REFUSAL OF PLANNING PERMISSION

APPLICATION NO. 2013/1352

Proposal Erection of 3 no. detached dwellings (Outline)

At Hawthorne House, New Row Lane, Ingbirchworth, Barnsley, S36 7GG

HOUSING DEVELOPMENT RESIDENTIAL CURTILAGE AT HAWTHORNE HOUSE
1:500 SITE LAYOUT
DRG A1 11/2013

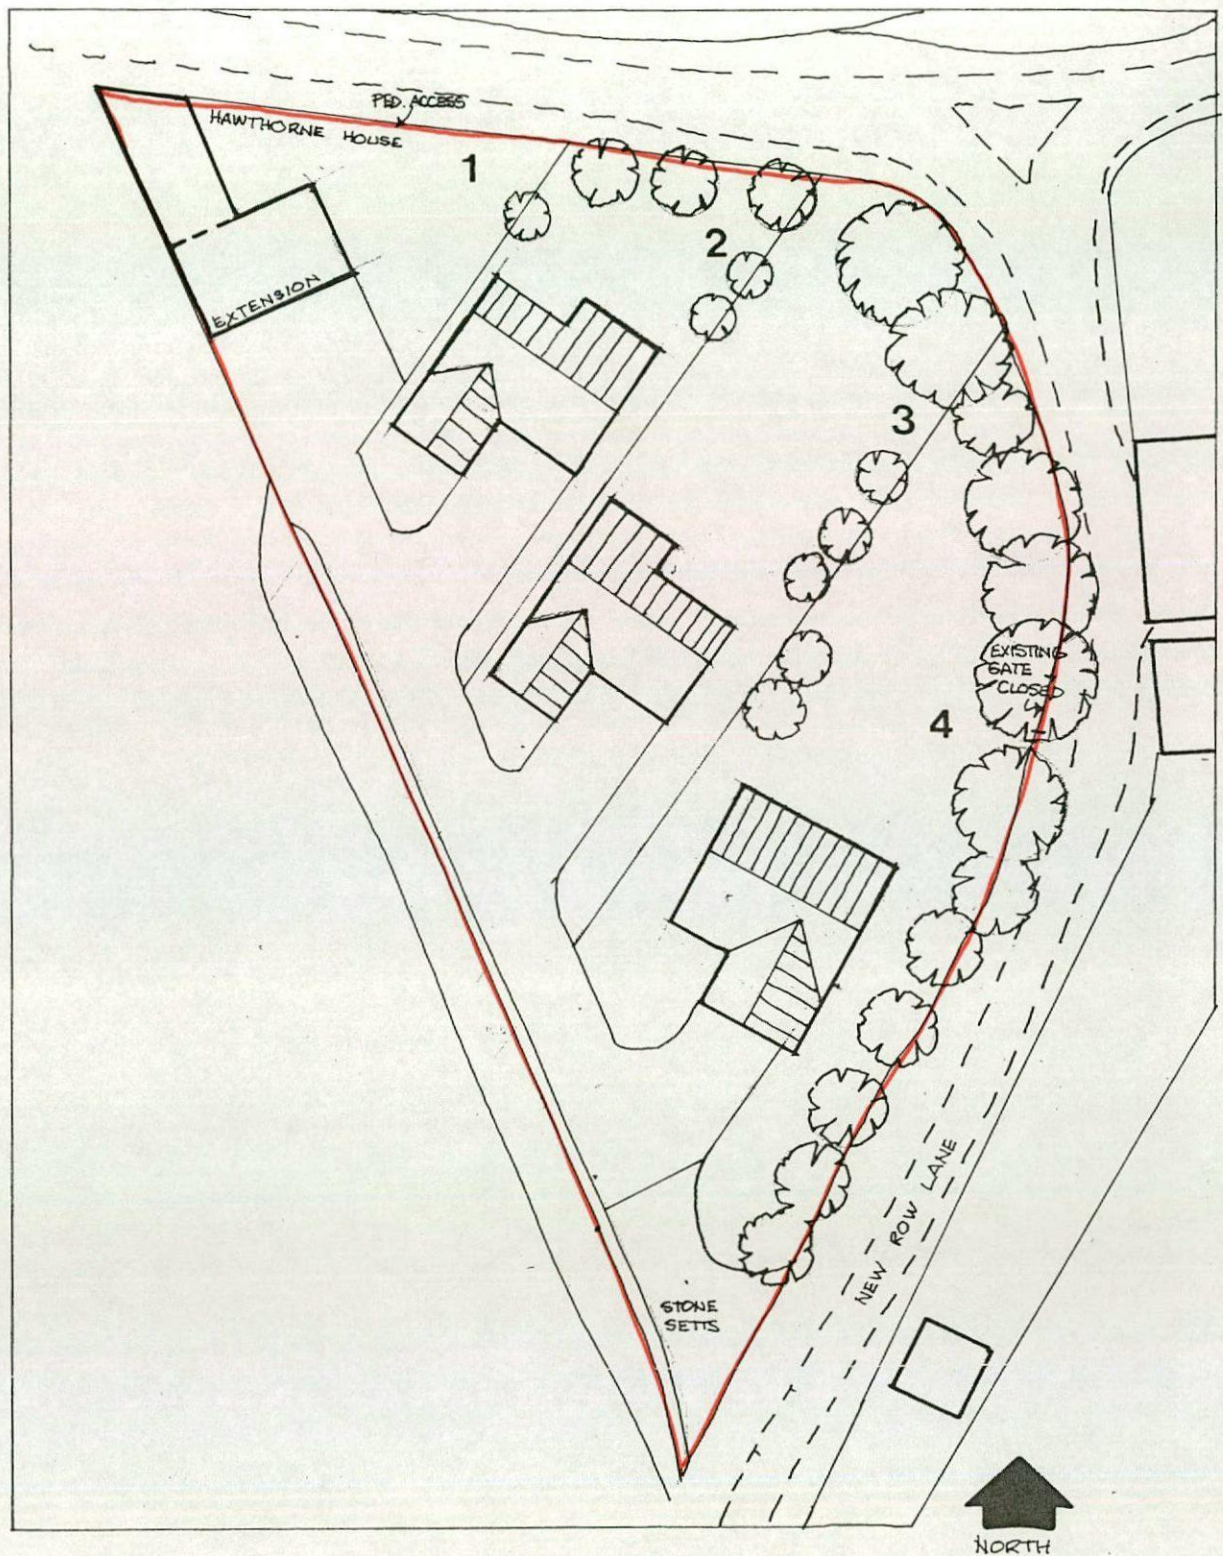
- 3 The application fails to demonstrate that harm would not be caused to the trees on the site that are protected by a Tree Preservation Order, which have the potential to be threatened due to the close proximity of the proposed works. It is considered that this could result in further harm being caused to the character and appearance of the Ingbirchworth Conservation Area contrary to Core Strategy policy 30 'The Historic Environment', saved UDP policy WR19, and Section 12 of the NPPF.

- 4 The proposals are contrary to Core Strategy Policy CSP26 'New Development and Highway Improvement' in that the proposed means of access for the development is not of an acceptable design as it not located perpendicular to the highway, fails to provide adequate visibility for vehicles emerging onto the highway, and does not enable the provision of 2 way traffic flows at the access to the site, to the detriment of highway safety.
